**Memorandum  
ABP-319843-24 –  
Request for Further  
Information**

**To:** Una Crosse, ADP  
**From:** Máire Daly, SPI  
**Re:** 319843-24 – Request for Further Information  
**Date:** 29<sup>th</sup> January 2025

DRAWN: R.H	CHECKED: S.H	APPROVED: I.B
PROJECT NUMBER: 23173	DATE: AUGUST '22	SCALE @ A1: 1:200
STATUS DESCRIPTION: FOR INFORMATION		STATUS: S2
DRAWING NUMBER: 23173 - MWP - 00 - 01 - DR - C - 0105	REV: P08

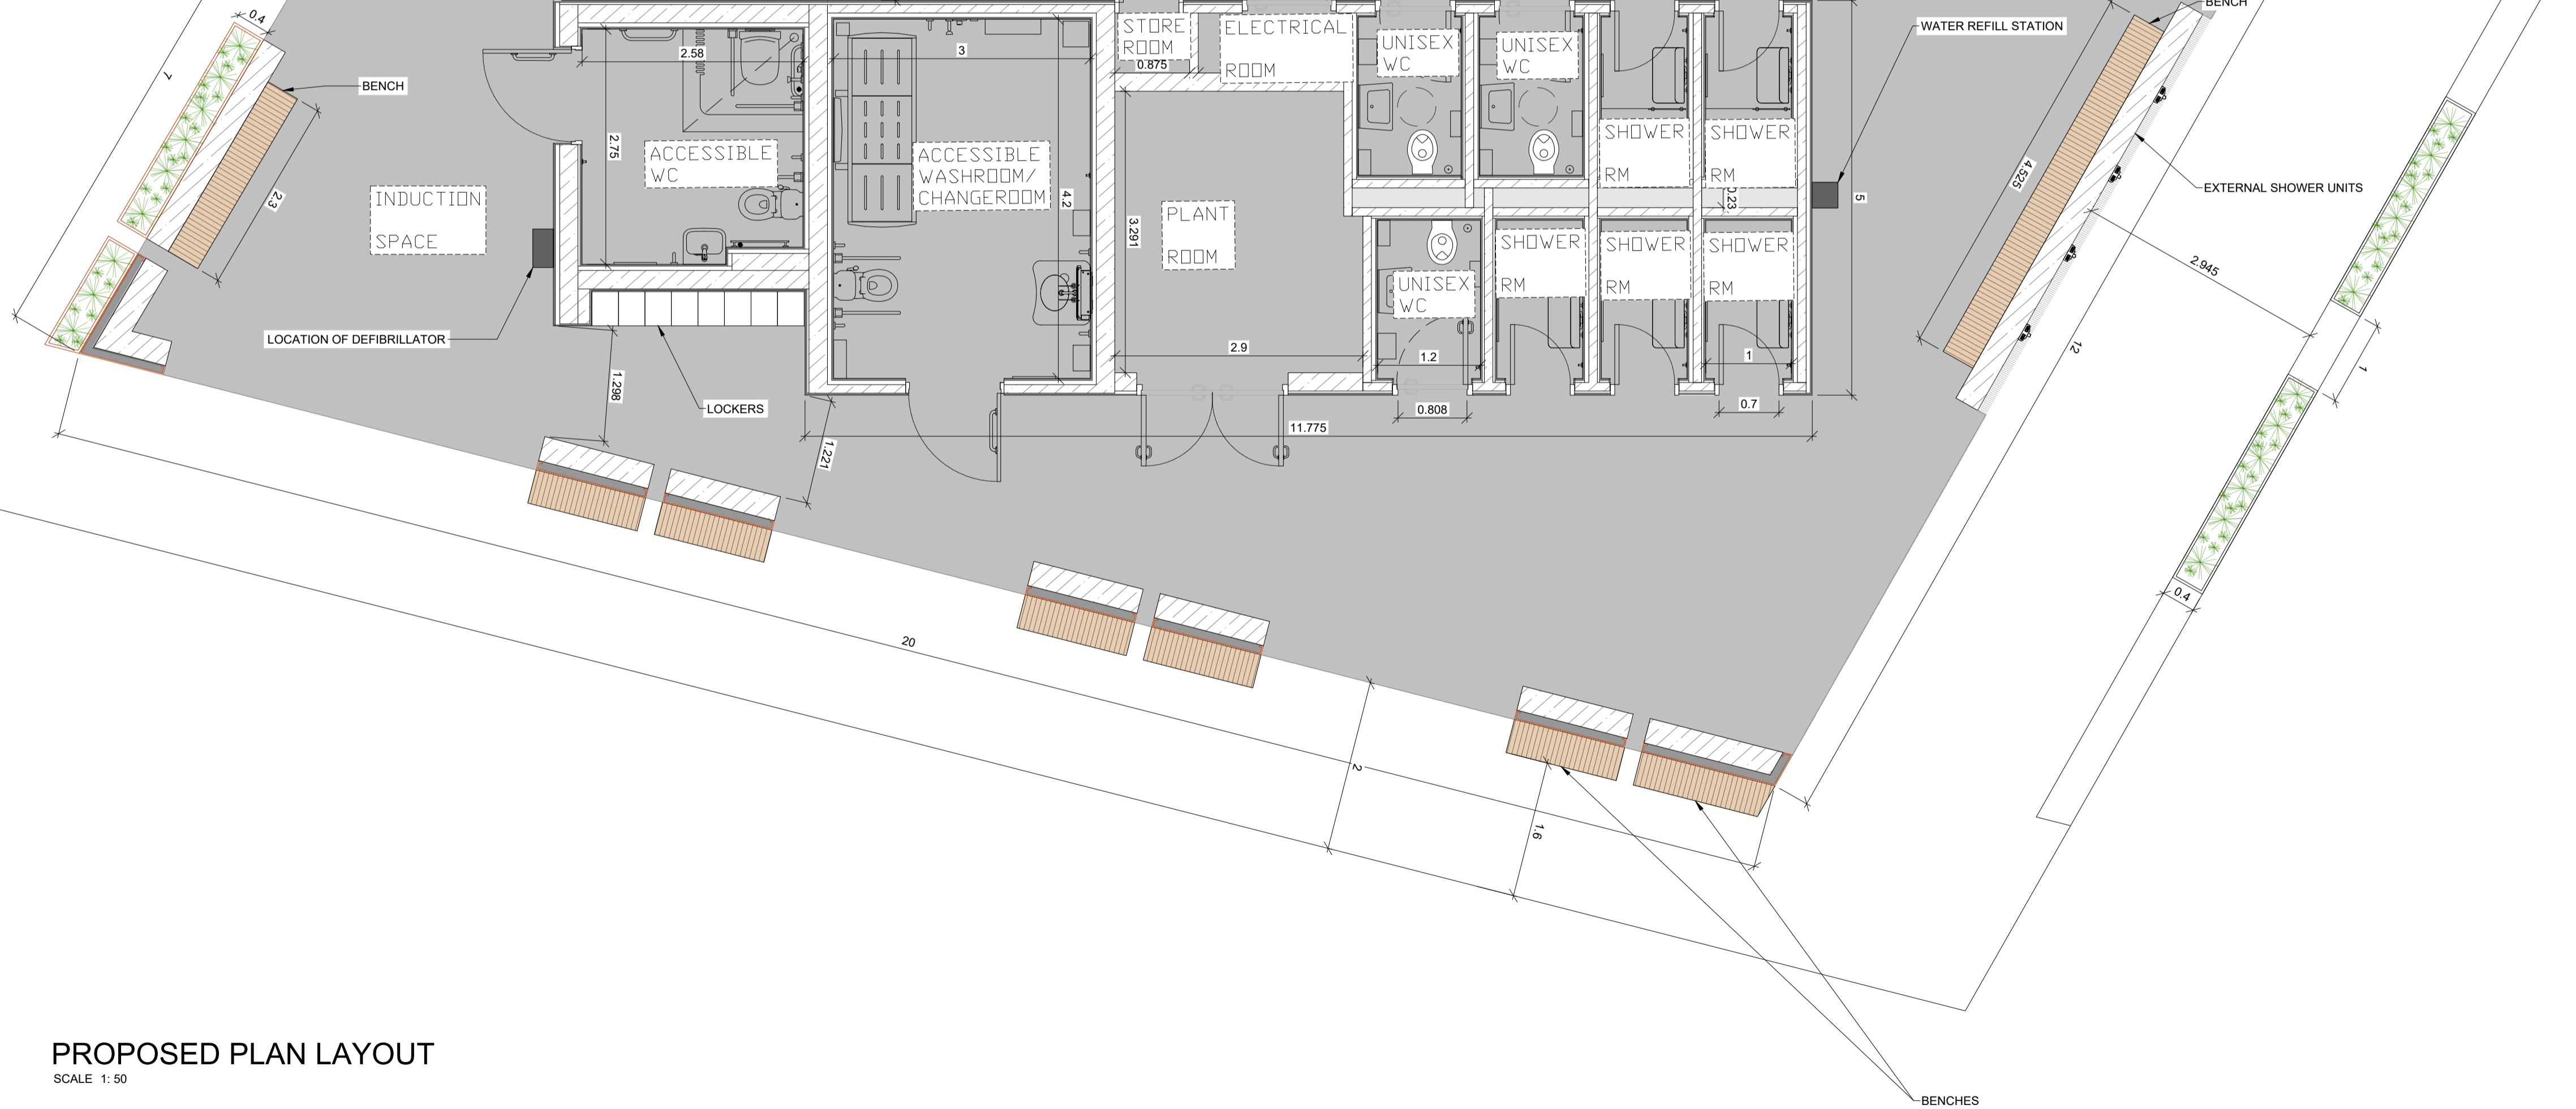
- iii. Identify each unlabelled structure/item shown on the submitted Proposed Water Services Drawing no. 23173-MWP-00-01-DR-C-0105 including items within the vicinity of the underground percolation area and those along the northeastern part of the site, in particular that which is to be connected to the proposed foul drain. The existing toilet block on site should be removed and the updated site layout plan should reflect this.

- iv. Correctly identify the area where the proposed underground percolation system is to be located, this location should also be reflected on Drawing no. 23173-MWP-00-01-DR-C-0105 and referred to in an updated NIS. In addition the NIS should be updated to include the most up to date version of drawing no. 23173-MWP-00-01-DR-C-0101.

DRAWING NUMBER: 23173 - MWP - 00 - 00 - DR - A - 0420	REV: P01
---	----------

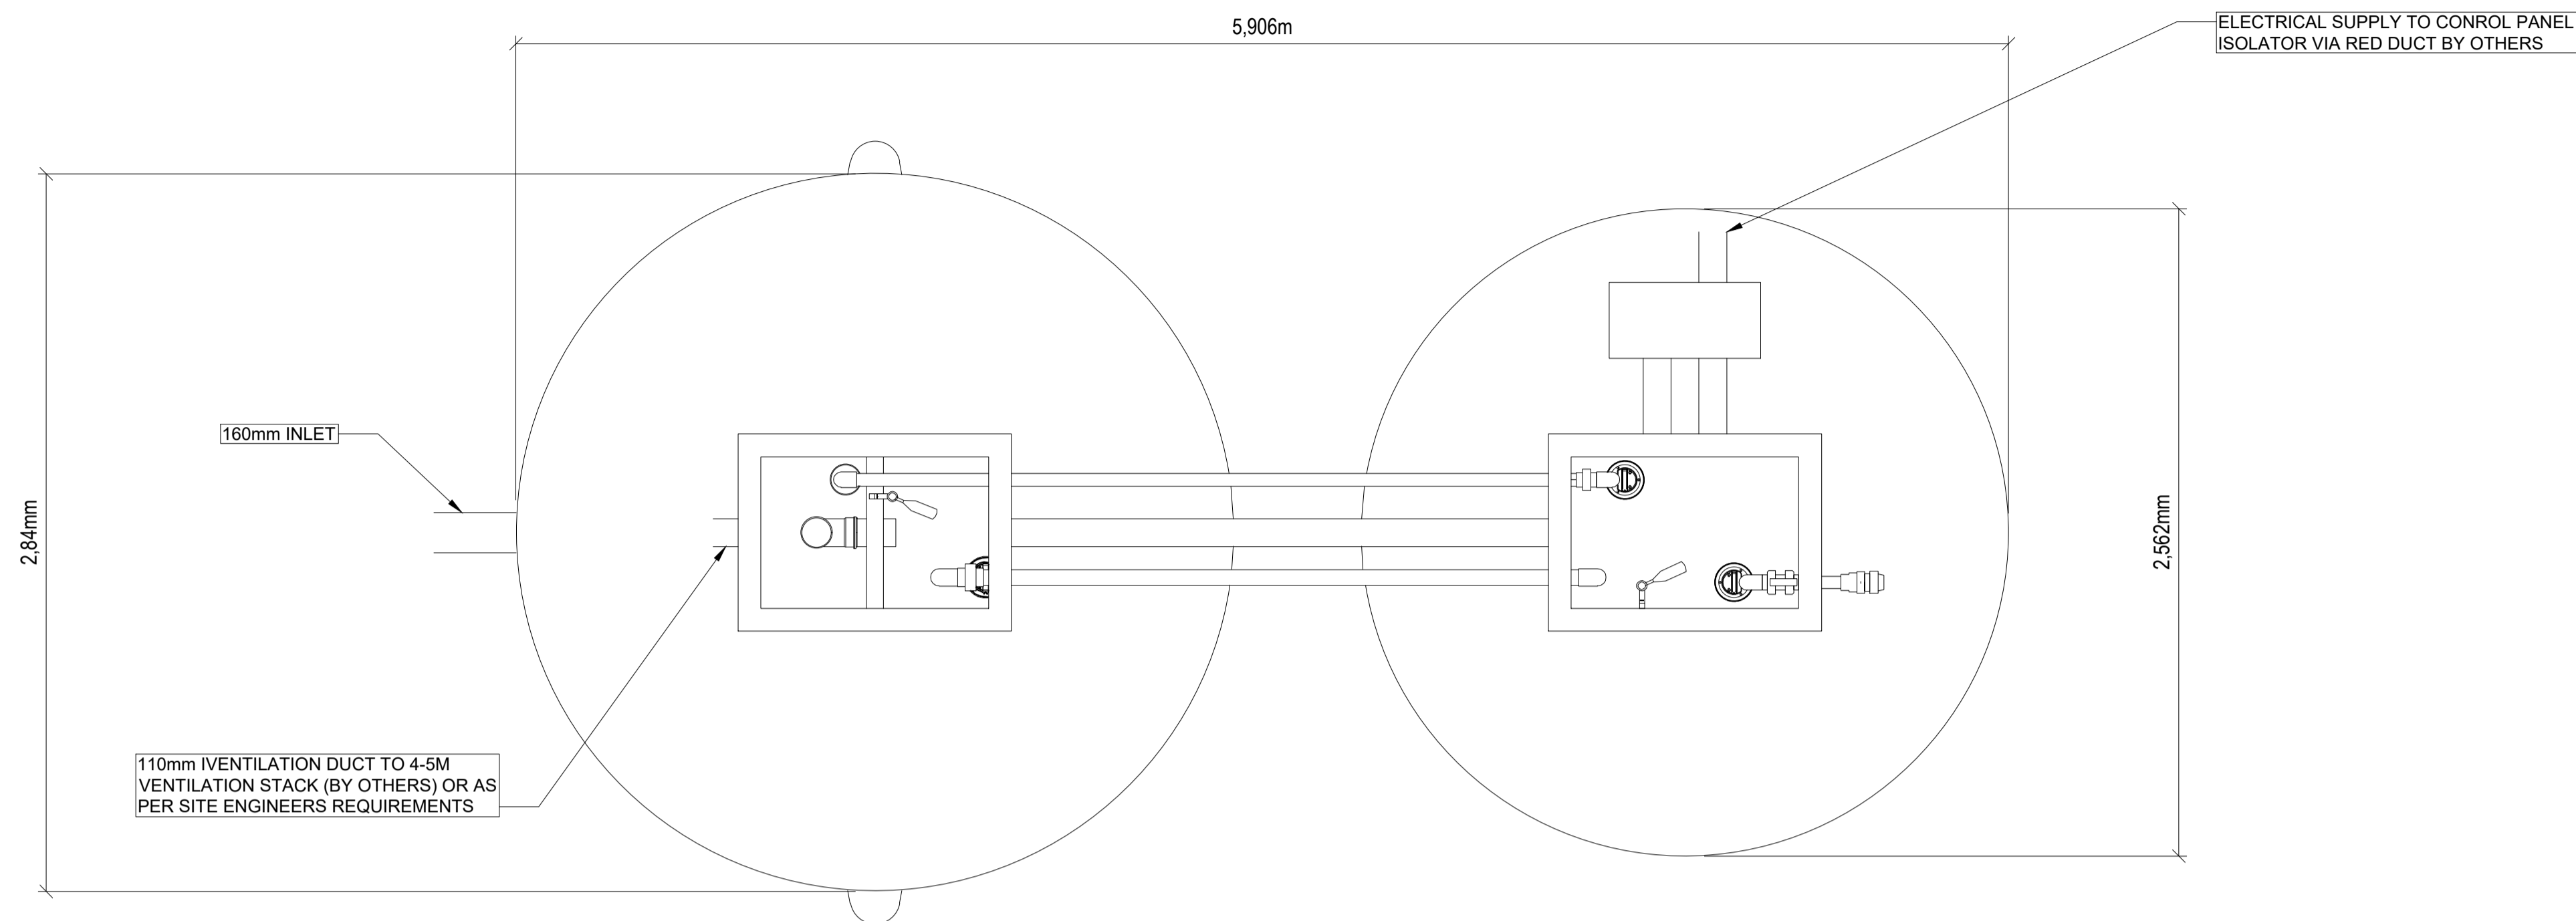
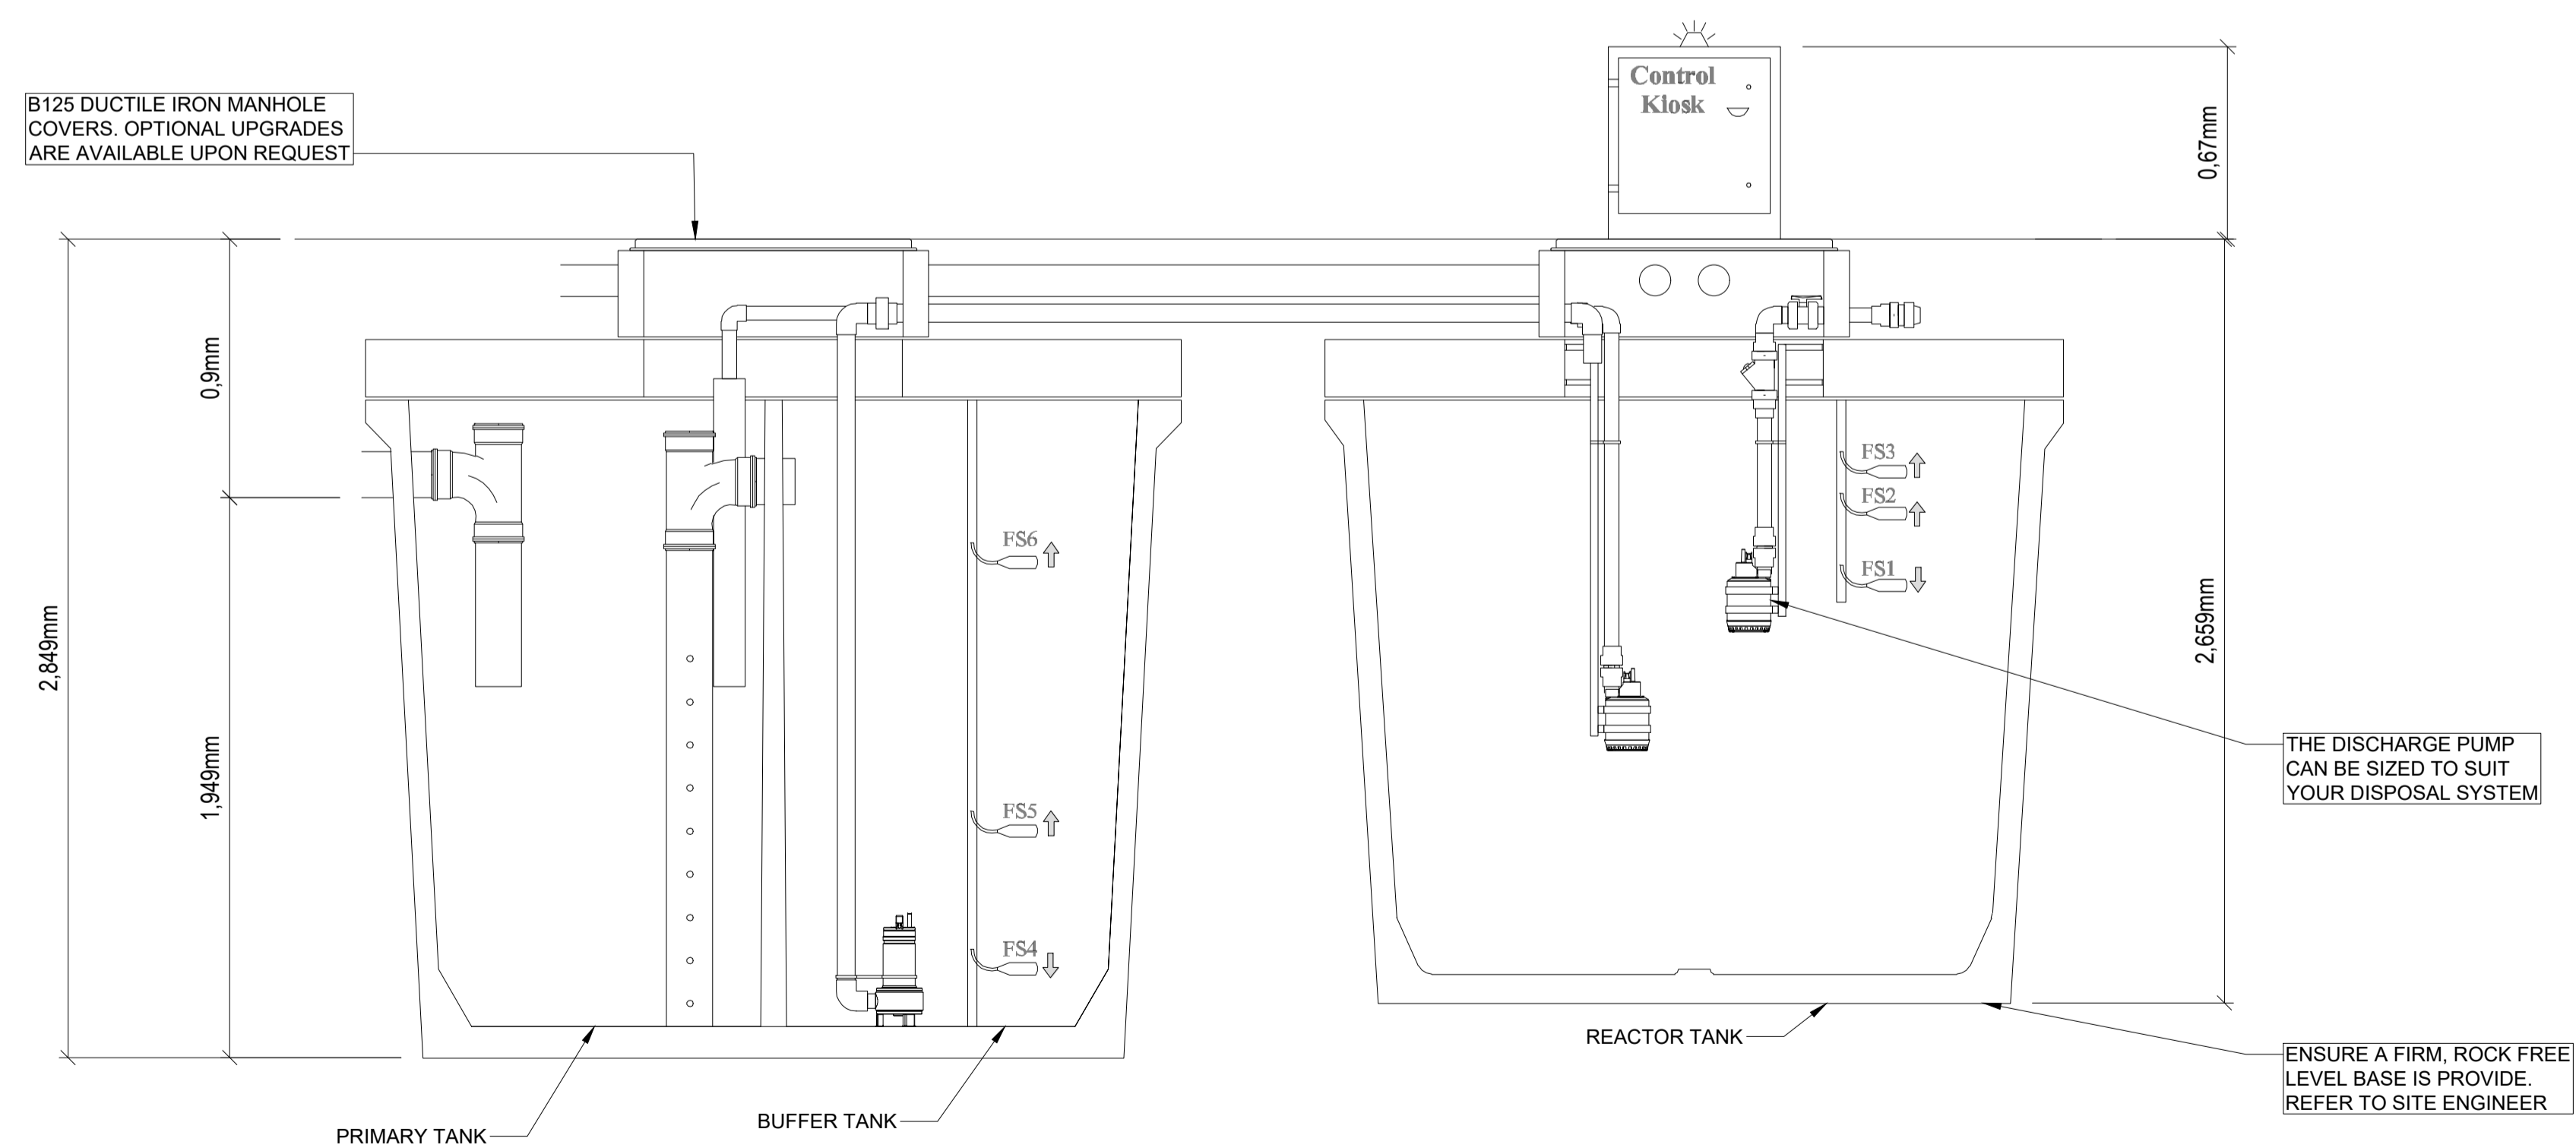
Ground elevation levels are absent from the submitted site layout drawings and therefore it is not clear what the changing levels are and the differing levels between the site entrance and the disabled access ramp. Likewise, with regard to the wastewater treatment plant, the relationship in level between the facility producing the wastewater and the treatment facility receiving the wastewater is also not clear. While noted that the Wastewater Treatment System document does provide invert levels on the Cross Sections (23173 MWP 00 00 DR A 0420) on page 40/41, there is no way of cross referencing these with actual ground levels.
